Introduction

1. Following the assessment of the three cumulative Transportation Assessments (TAs) for the Pagham residential developments, and due in part to the significant variation between the analysis results from those reports, but also in light of comments about robustness, the recommendation was made that a Sensitivity Analysis of certain junctions be undertaken.

2. The purpose of the Sensitivity Analysis by DBA is in order for Arun District Council (ADC) to be able to inform members on the sensitivity of the impact of the identified sites, and the robustness of conclusions on traffic impact and mitigation. There are a number of issues relating to proposed improvements and absence of improvements that are considered in this report, prior to a final position being stated. The phasing of improvements also needs to be considered by ADC.

Full Input Data And Results
Network Layout Diagram

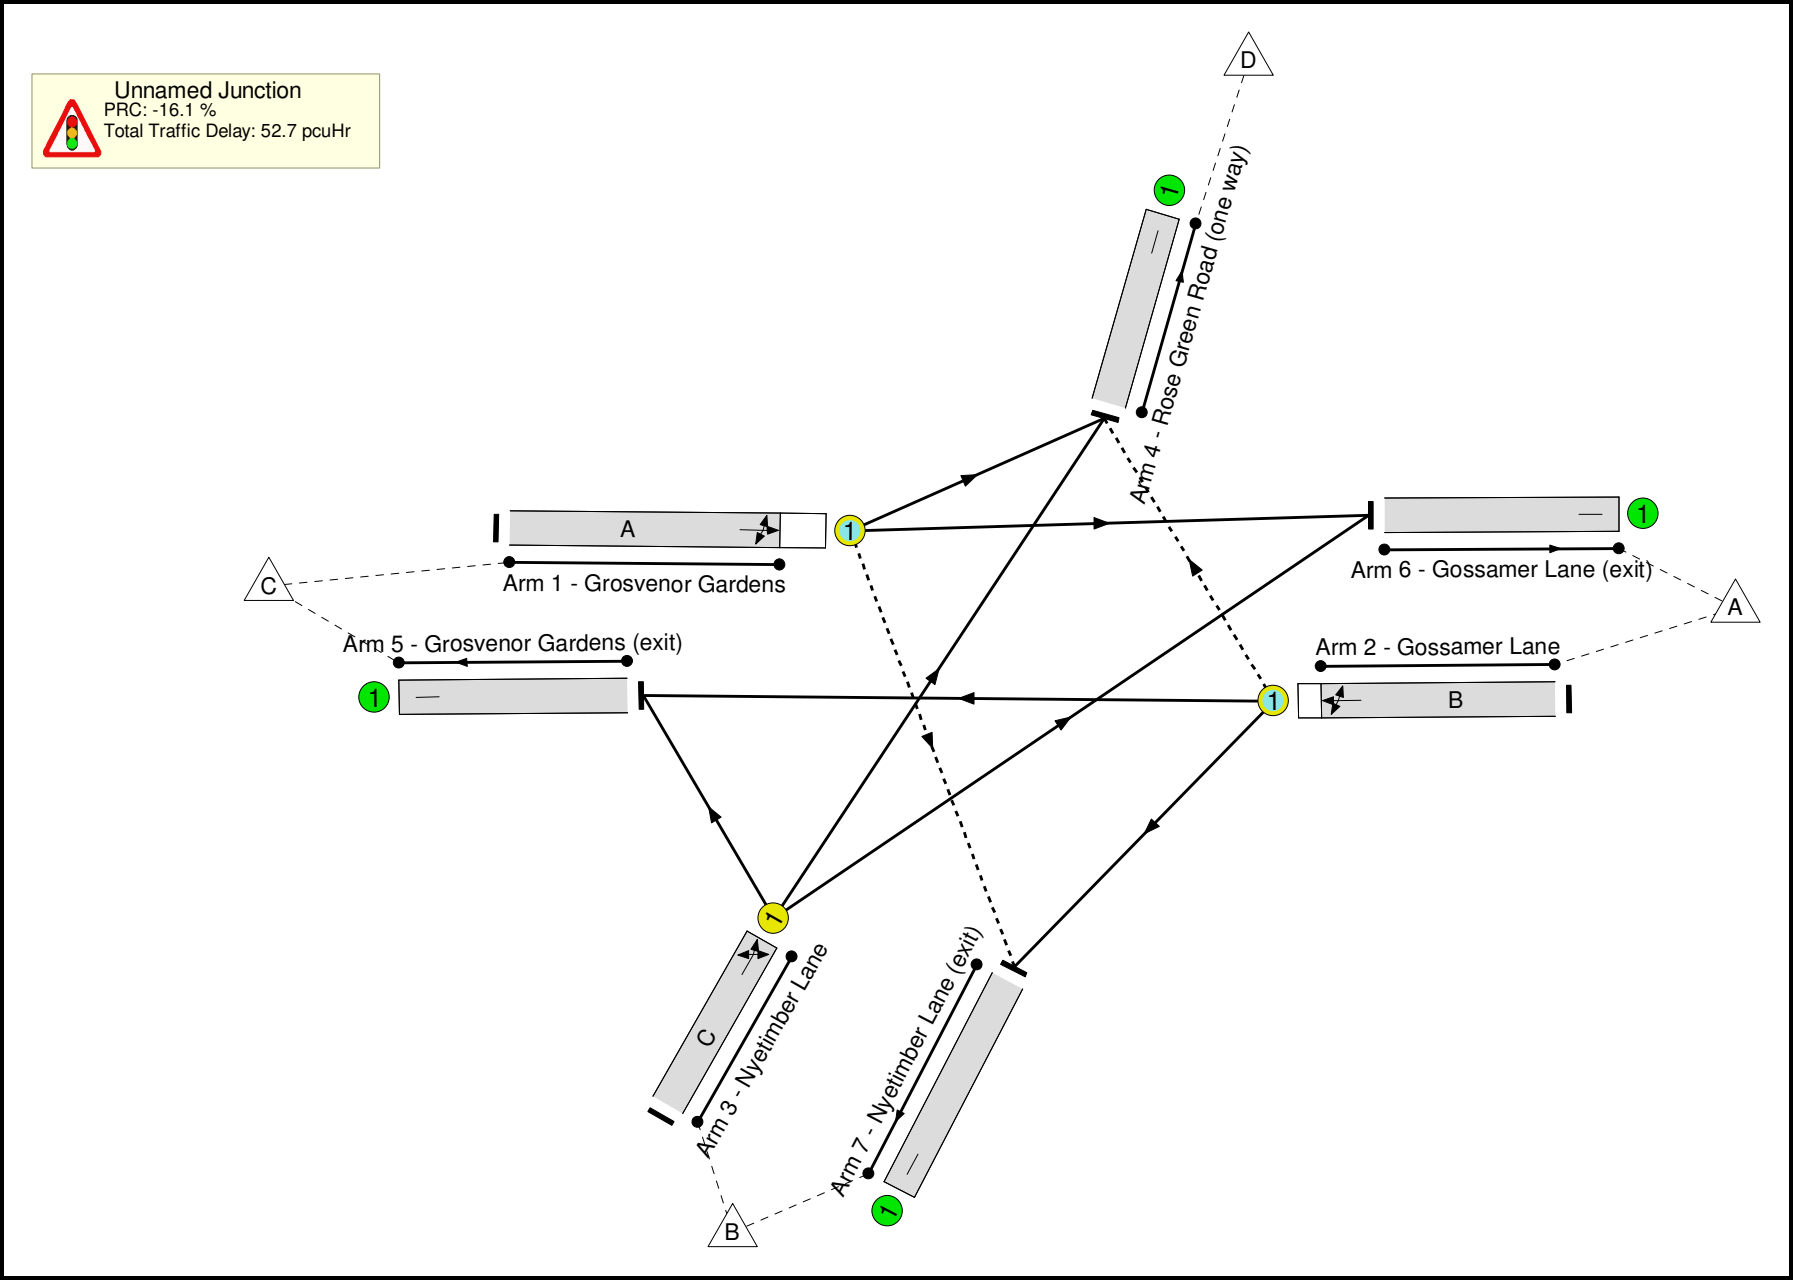
28. On review of the models presented, a particular issue noted was the green time applied to the pedestrian stage. This shows a 7-second green time for pedestrians with no preceding inter-green time separating the pedestrian crossing stage from the previous traffic stage. The inter-green following the pedestrian stage is shown as only 2 seconds. It is not known whether these are confirmed timings on the ground, but in any case they are fundamentally substandard according to pedestrian crossing design requirements, as set out in the Design Manual for Roads and Bridges (DMRB).

29. Notwithstanding the above, DBA have modelled both the presented situation (in the Pagham TAs) and a situation with more appropriate inter-green times. Similarly, in respect of signal total cycle time, it is noted that 90 seconds has been applied without variation. This Sensitivity Analysis considers the effect of a longer cycle time (up to maximum 120 second) to assess whether any benefits would result.

31. DBA's sensitivity test of the signal timings applies a preceding inter-green of 8 seconds, and a following inter-green of 7 seconds to the pedestrian stage at this junction. The result is 2031 committed base results of 91.1% DoS (PRC -1.2%) AM and 90.6% DoS (PRC -0.6%) in the PM. Including sensitivity combined development traffic results in 96.8% DoS (PRC -7.5%) AM peak and 97.5% (-8.3%) PM peak.

32. It is important to note that, if the pedestrian stage is not called, and all of the 90-second cycle is devoted to traffic stages, the maximum DoS values are 74.3% (AM) and 73.8% (PM), with PRCs of 21.1% (AM) and 22.0% (PM). In the absence of actual survey data, it seems likely that the reality would be a pedestrian stage that is called not in every cycle of the lights, but in a proportion of the cycles in the peak hours. This, for practical purposes, the results for future junction operation would lie somewhere between the highest sensitivity results and the no-pedestrian stage values.

45. **Grosvenor Gardens / Rose Green Road signals** – If the signal timings presented in the Pagham TAs are applied, sensitivity analysis indicates that the proposed development traffic would be accommodated at this junction in the future design year. If timings are applied to the pedestrian stage that take account of current standards and the requirements of pedestrian safety, modelled development impact would be higher. The question of whether combined development traffic would be accommodated with suitable signal timings depends on pedestrian stage call frequency during peak hours. In the absence of specific data, and given the nature of the location, it is considered reasonable that a balance would be struck favouring pedestrian safety. It is concluded therefore that no mitigation works would be required in this location.
